Specific Issue Hearing on the compensation proposals (Monday, 12 and Tuesday, 13 November 2012)

Written summary of oral representations by Natural England

Figure 2: Location of the 12 intertidal transects with upper, middle and lower shore sampling stations at each.

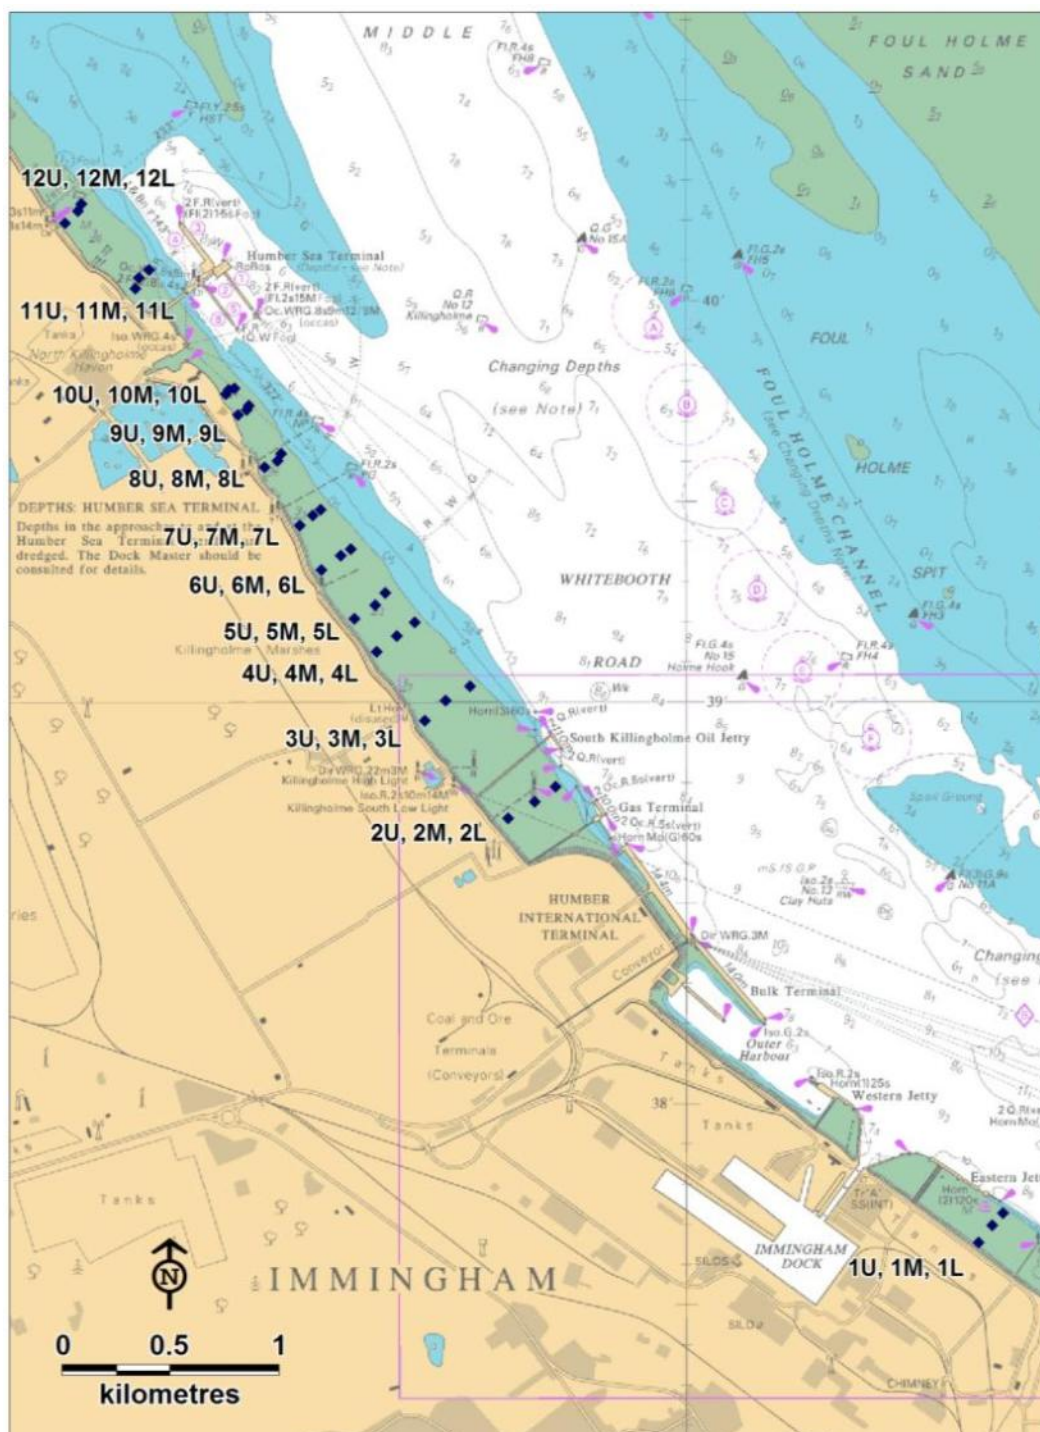
11. However, the Applicant asserted ahead of these hearings that "[t]here is no objective evidence that the Killingholme Marshes foreshore contains an especially high prey density compared to the rest of the middle estuary" (Comments on answers to 2Qs, para.10.4). Twelve transects were undertaken for the invertebrate monitoring work at Killingholme. Whilst the majority of birds were located in count sectors C & D; of the 12 transects only the third transect bisected sectors C & D with the fourth and second transects passing along the northern and southern boundaries respectively. In addition samples were taken during a period (May) when invertebrate biomass will be depleted.⁵

Figure 1: Intertidal benthic invertebrate sampling stations

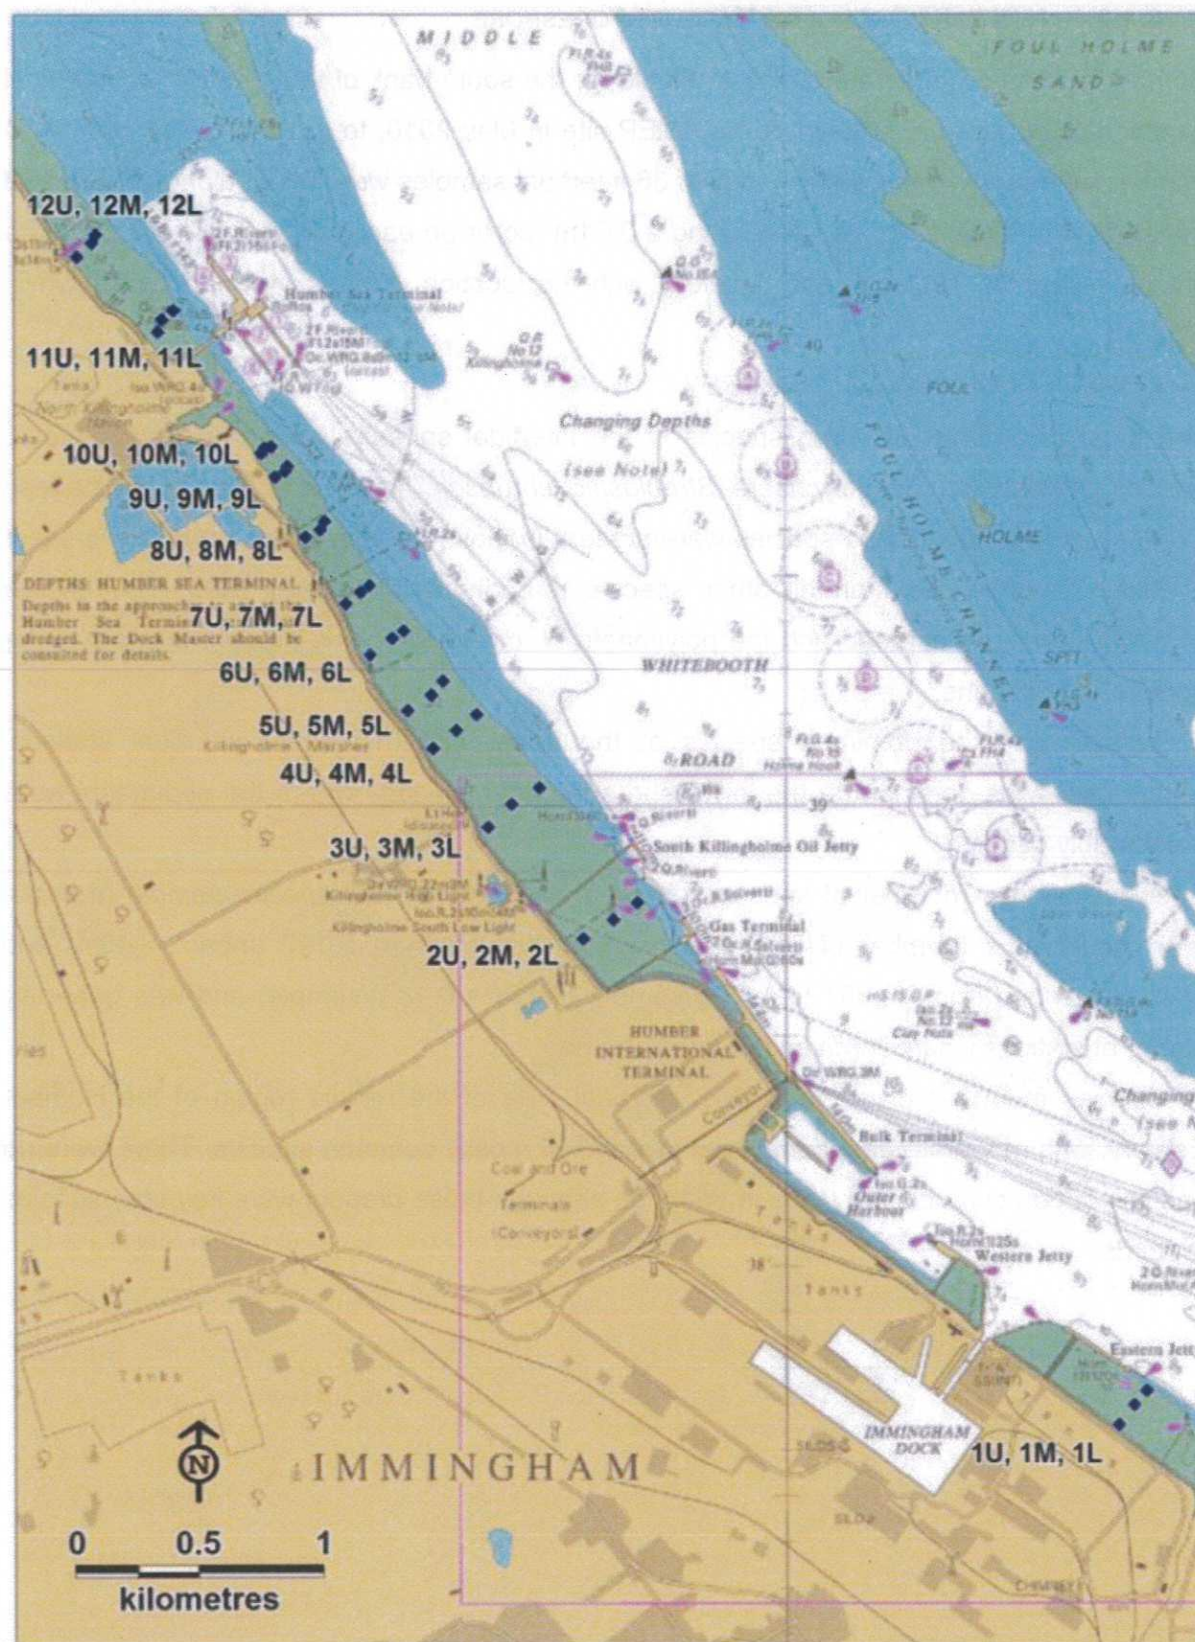
12. Invertebrate data for the Humber Estuary (Allen 2006) were used in comparison to Killingholme data (IECS 2010) to show that availability of bird food at Killingholme was similar or less than at other areas within the estuary. Natural England contacted IECS before the hearing to query the surprising nature of these results, at odds with the observed distribution of birds that feed on these invertebrates and followed these queries with a series of written questions to IECS. Analysing the additional data provided at the hearings has confirmed

Natural England's view that there are significant errors in the report and that the most likely explanation is that totals from a single sample site at Killingholme have been compared with totals from five samples for the rest of the Humber.
